Charlotte Department of Transportation

Memorandum

Date: March 4, 2008

Subject: Rezoning Petition 08-060: Located on the east side of Point O'Woods Drive and the west side of Northlake Centre Parkway

RZ-2.0

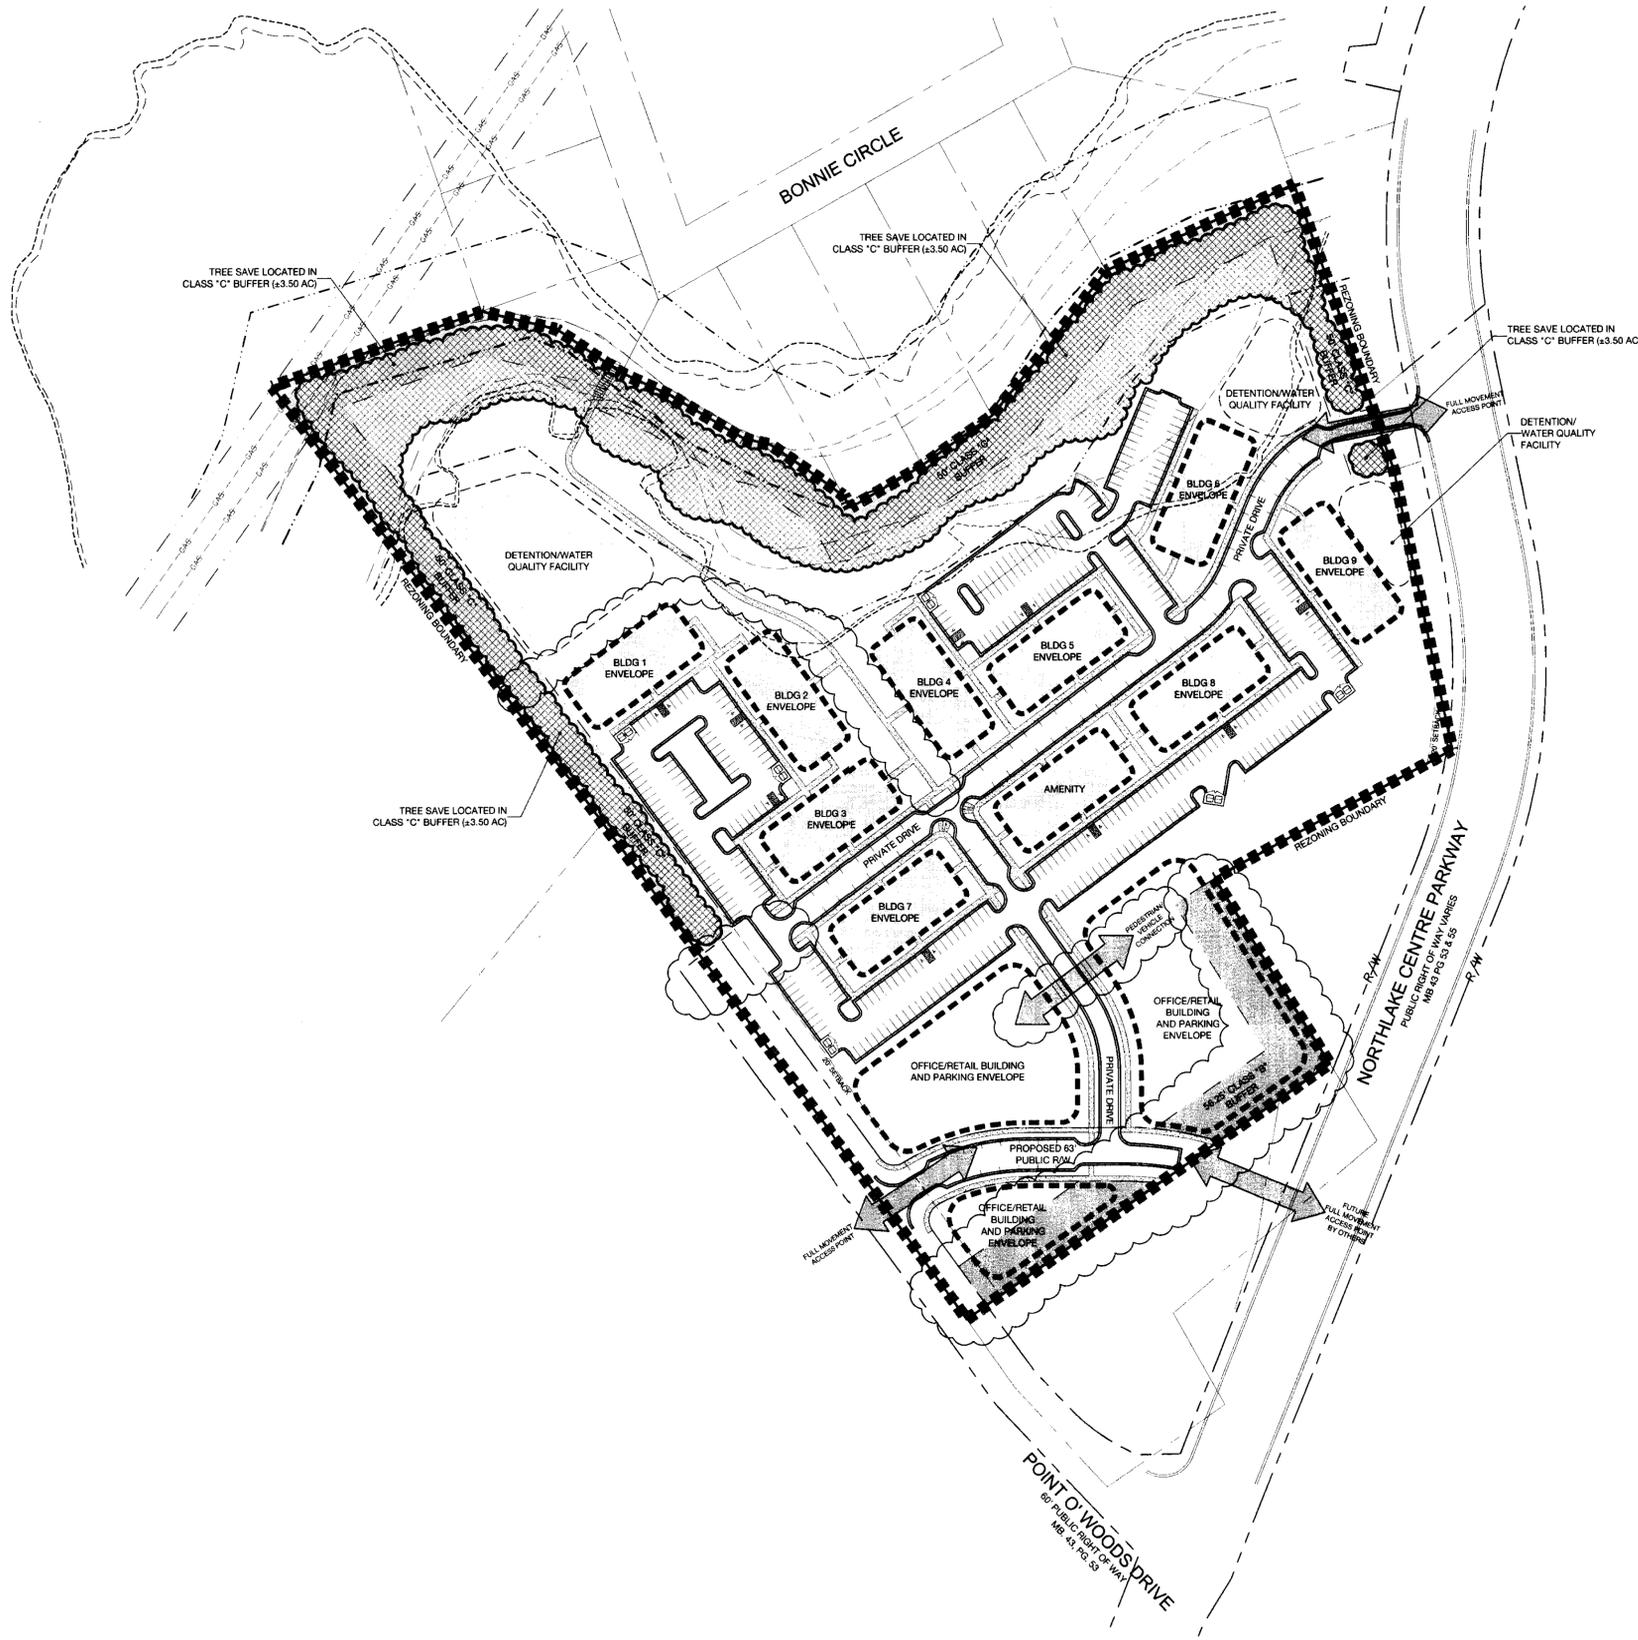
that a left-turn lane is necessary to serve the traffic using the proposed public street/private driveway connections for this site. The engineering design and construction of the left-turn lane is the responsibility of the owner, and shall be performed by a professional engineer registered in the State of North Carolina who has roadway-design experience. CDOT will only approve the proposed connection provided that a left-turn lane is constructed on Northlake Centre Parkway. We recommend the rezoning plan reflect the design of this required left-turn lane prior to submittal/approval of the connection. This roadway improvement is required to meet the traffic demands of the proposed development. The left-turn lane needs to be designed with a *minimum* 150 feet of storage and 15:1 bay taper. The length of the storage will be determined through the TIS process.

2. The primary access point off Northlake Centre Parkway needs to be a public street that connects with existing Point O'Woods Drive and the adjacent Northcrest shopping center. The remnant portion of Point O'Woods Drive between Northlake Centre Parkway and this new street then needs to be abandoned and closed.

3. The street network needs to be designed so that a connection to the Northlake Mall Drive/Northlake Centre Parkway intersection through parcel 15 can be made in the future. The petitioner does not have to construct the road through Parcel 15 unless it is determined from the traffic study that it is necessary for mitigating traffic impacts. Upon connection to the Northlake Mall Drive/Northlake Centre Parkway intersection, the right-in/right-out access to Northlake Centre Parkway would need to be closed. It is strongly encouraged, however, that the petitioner seek to acquire Parcel 15 and construct the connection to Northlake Centre Parkway as part of initial site development.

4. The proposed conversion rates between retail/residential and office/residential appear to be incorrect. With the square footages given, the conversions would yield over 1,600 residential units (approximately 75 DUA), much higher than the proposed 17 DUA.

5. In conformance with the adopted Urban Street Design Guidelines, Residential Wide and Commercial Wide streets, as appropriate, need to be used in the site. These streets need to be public, although no street stub to the NCDOT-owned parcels is necessary. A 10-foot-wide bike/pedestrian connection will be sufficient.

6. The site plan needs to provide conceptual building, parking, and maneuvering layouts. Multi-use Center locations have preferred block lengths of 500' and maximum block lengths of 650'. Because of the intensity/density of the proposed uses, the preferred block length more appropriate.

Northlake Centre Parkway is an Avenue requiring a minimum of 115 feet of right-of-way. The developer/petitioner should convey right-of-way in fee simple title to meet this requirement, measuring 57.5 feet from the centerline of the roadway.

Adequate sight triangles must be reserved at the proposed street entrances. Two 35' x 35' sight triangles are required for the entrances to meet requirements. All proposed trees, berms, walls, fences, and/or identification signs must not interfere with sight distance at the entrance(s). Such items should be identified on the site plan.
